Subject: RE: AW/237/19/PL The Former Ship Inn, Aldwick

Many thanks for the documents which I have been able to review and provide some comments for you, attached. Whilst the RSA does not propose anything new to what has already been approved under the original planning approval, the updated tracking does show that an articulated lorry would not be able to use the car park for loading and unloading without over running the northern buildout. We have also noticed that any articulated movements

Title
Site Location Plan with Vehicle Tracking : Articulated Vehicle

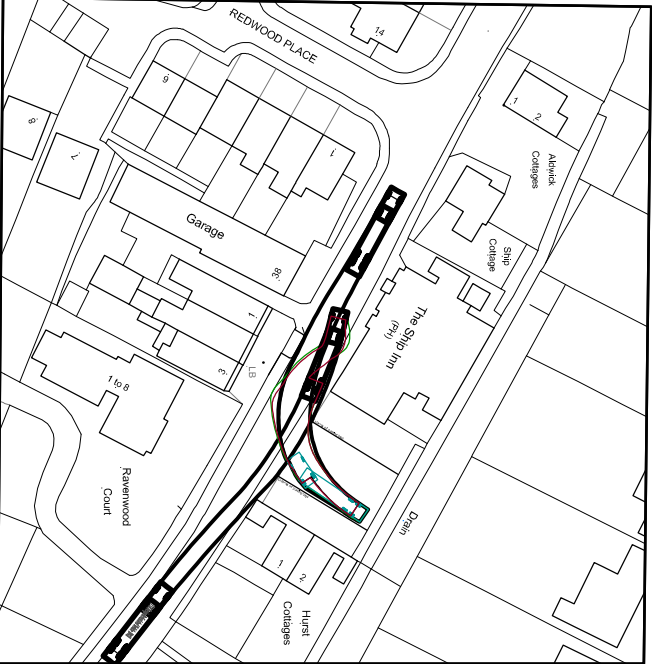
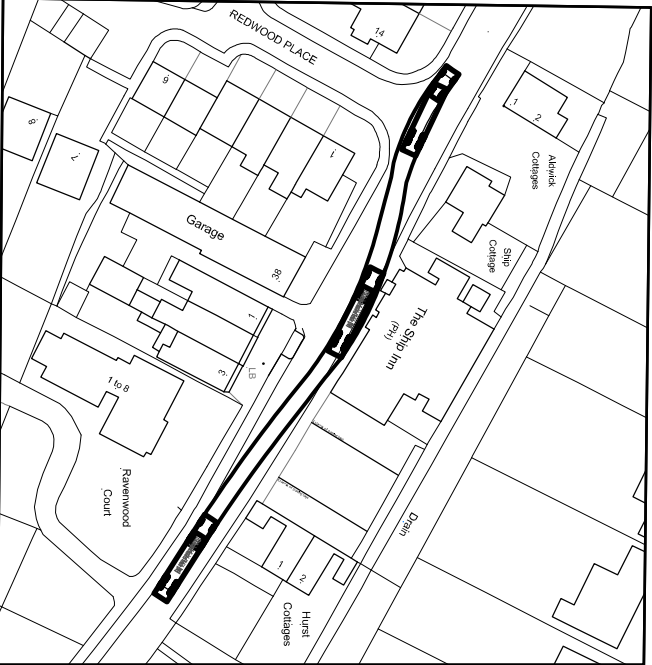
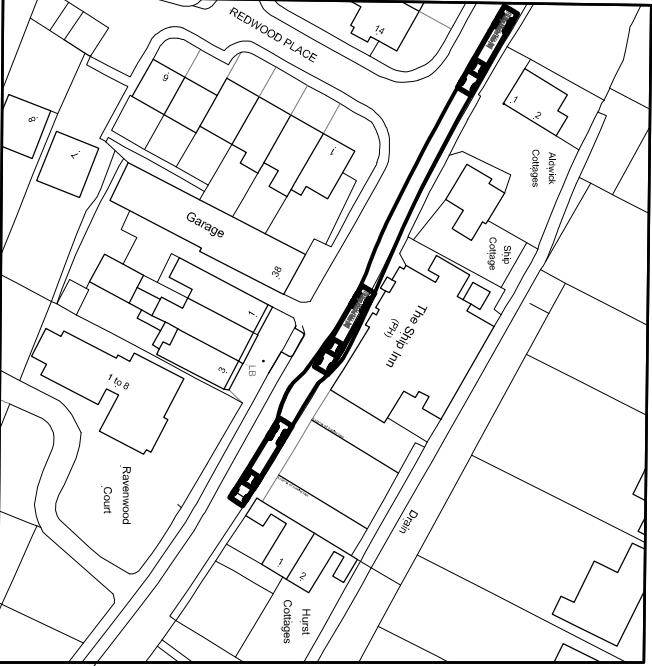
should preferably travel to the site from the west and leave from the east to avoid over running the northern build out. This should be reflected in the delivery management schedule. Clarification should be sought over whether the existing bollards in the highway will remain, as it is not clear where these are in relation to the tracked vehicle.

WSCC has reviewed the swept path diagrams and would agree that articulated vehicles should only use the area adjacent to the building, however all rigid vehicles could safely use the car park as well. It is also noticed that Articulated vehicles over run the northern buildout if travelling in a westerly direction (from the east). As such WSCC would recommend these lorry are encouraged to access the site from the west and leave to the east. The delivery management schedule should be updated to reflect this.
